WELWYN HATFIELD COUNCIL – DEVELOPMENT CONTROL
DELEGATED REPORT

APPLICATION No:	S6/2008/444/FP
------------------------	-----------------------

This application seeks full planning permission for a loft conversion incorporating front and side dormers and a conversion from a hip roof to a gable roof at the rear.

PROPOSED LOFT FLOOR LAYOUT

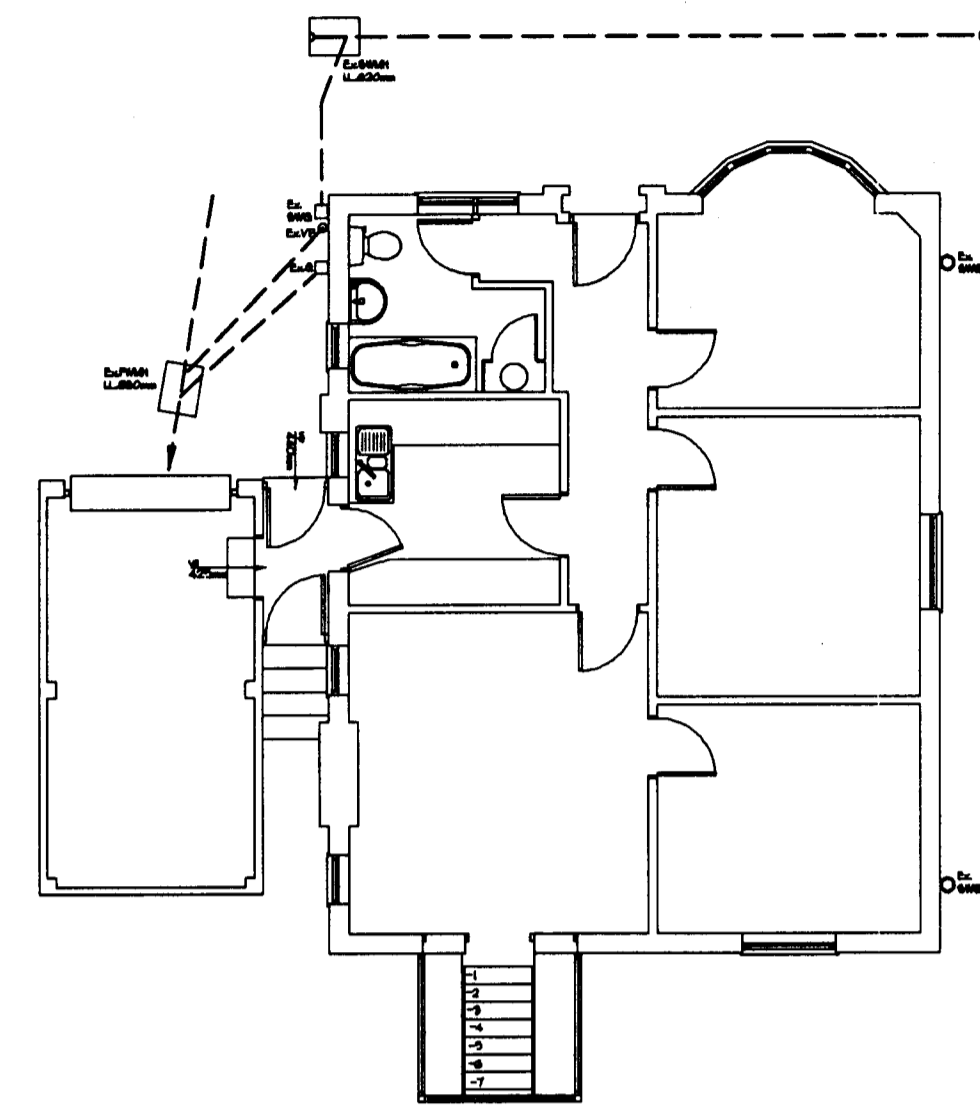
The single dormer proposed in the front elevation would feature a hipped roof continuing at the same height as the existing ridge. The side dormers would feature flat roofs set approximately 200mm below the ridge. Each side dormer would project approximately 3m. The south side dormer measures 3.2m in length and features one window serving a bedroom. The north side dormer measures 4.1m in length and features two windows, one serving a bedroom and the other a shower room. It is also proposed to convert the existing hipped roof at the rear to a gable with a window at the centre. The accommodation would provide for two additional bedrooms and a shower room. The gable and dormers would feature plain red concrete tile hanging.

PROPOSED ELEVATIONS - 1:100

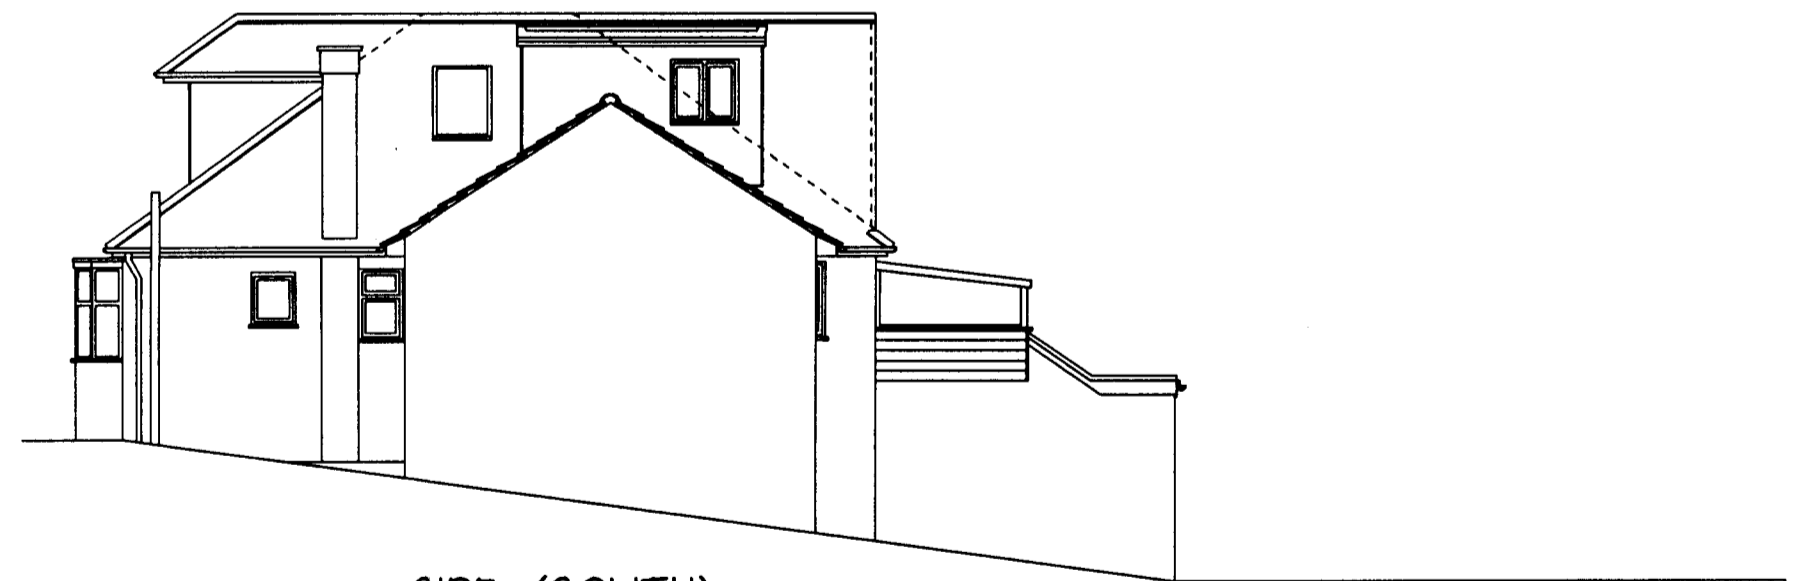
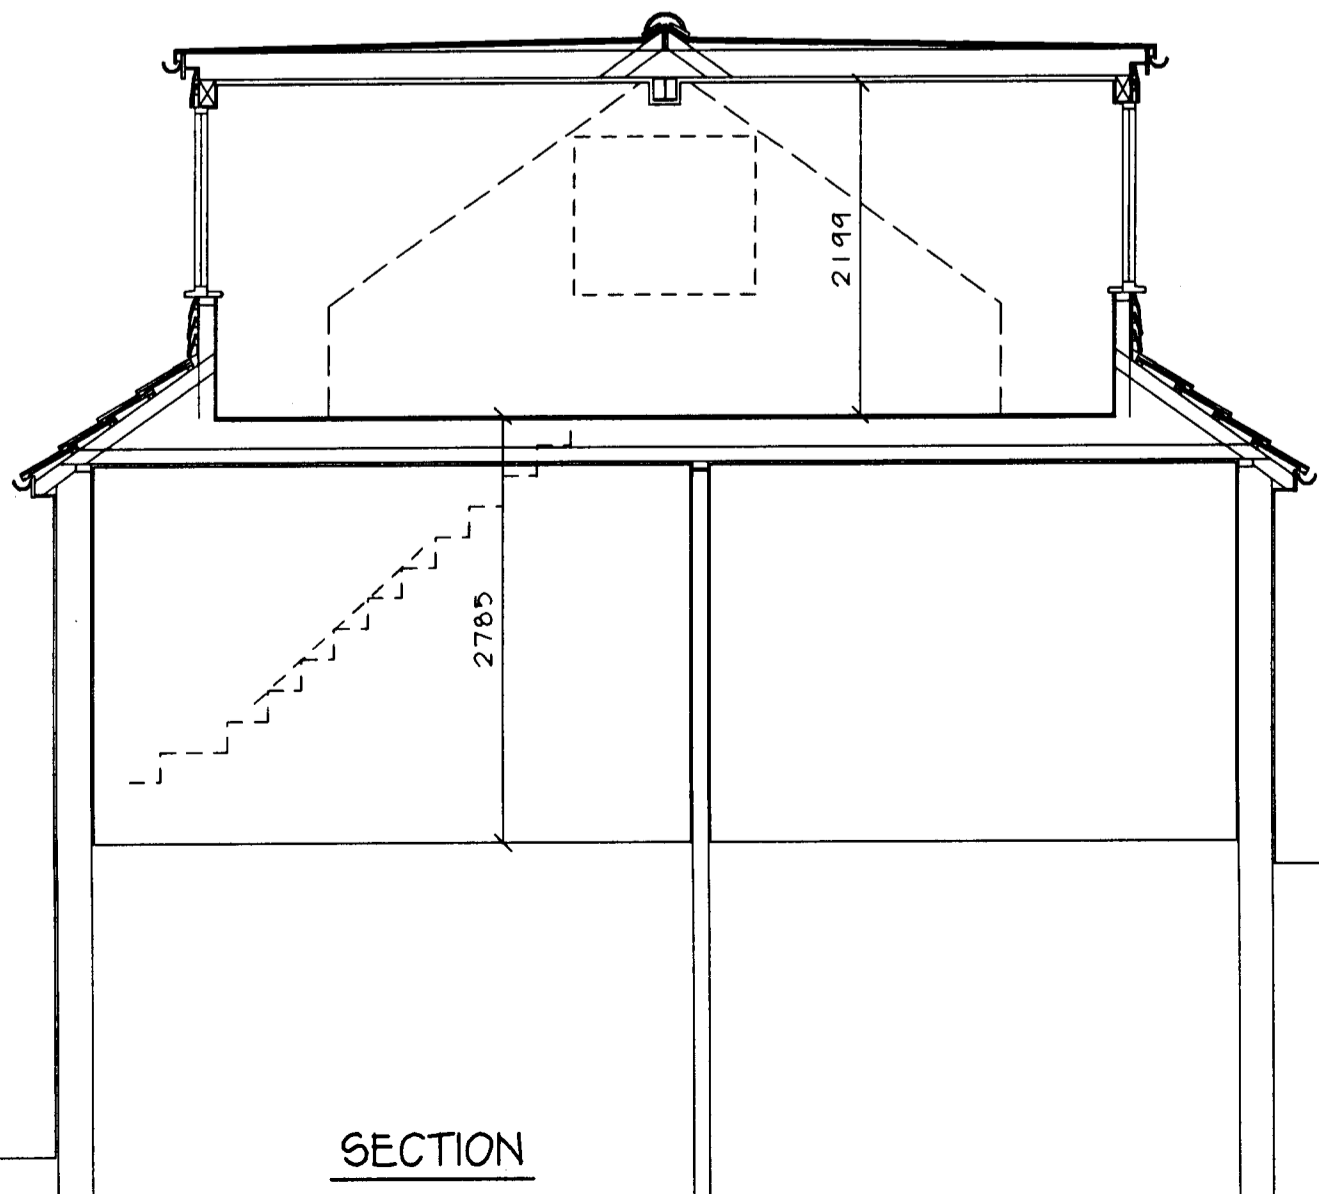
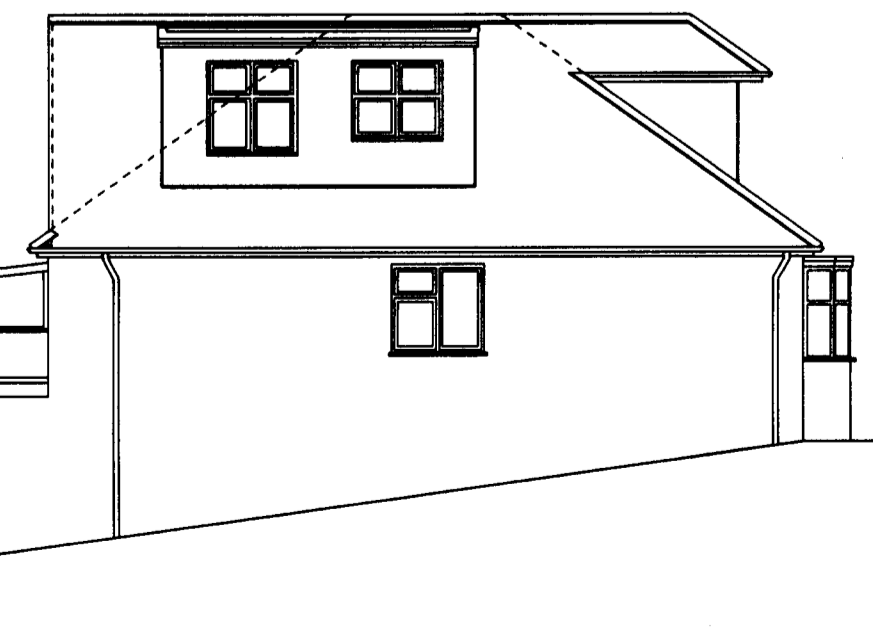
Although the proposed side dormers have been reduced in length following refusal of planning application S6/2007/0539/FP, they retain the same height and width and therefore would appear largely unchanged when viewed from the street. The current scheme would retain the existing hip to the front which is an improvement over the previously refused scheme to convert the hipped roof to a gable, however the proposed dormer to the front elevation would appear out of scale with the original bungalow. Therefore it is considered that the proposals fail to overcome reason 1 for refusal of planning application S6/2007/0539/FP.

It is considered that the reduction in the length of the proposed dormers would overcome reason 2 for refusal of planning application S6/2007/0539/FP provided that a condition was attached to any grant of permission to ensure that the dormer windows to the side were fixed and obscure glazed order to prevent an unacceptable loss of privacy to the adjacent dwellings.

The proposed dormers would be out of scale with the original bungalow and would introduce additional bulk and mass which would not appear subordinate to the original dwelling. The design of the proposed extension would adversely affect the character of the existing dwelling and the character of the immediate street scene. The proposal therefore fails to comply with Policy D1 and D2 of the Welwyn Hatfield District Plan 2005 and Supplementary Design Guidance, February 2005 (Statement of Council Policy).

1. The proposals by reason of their scale, mass and incongruous design would adversely affect the character of the existing dwelling. The proposed dormers would create a roofscape which is not subservient to the original dwelling contrary to Policies D1 and D2 of the Welwyn Hatfield District Plan 2005 and Supplementary Design Guidance (Statement of Council Policy).
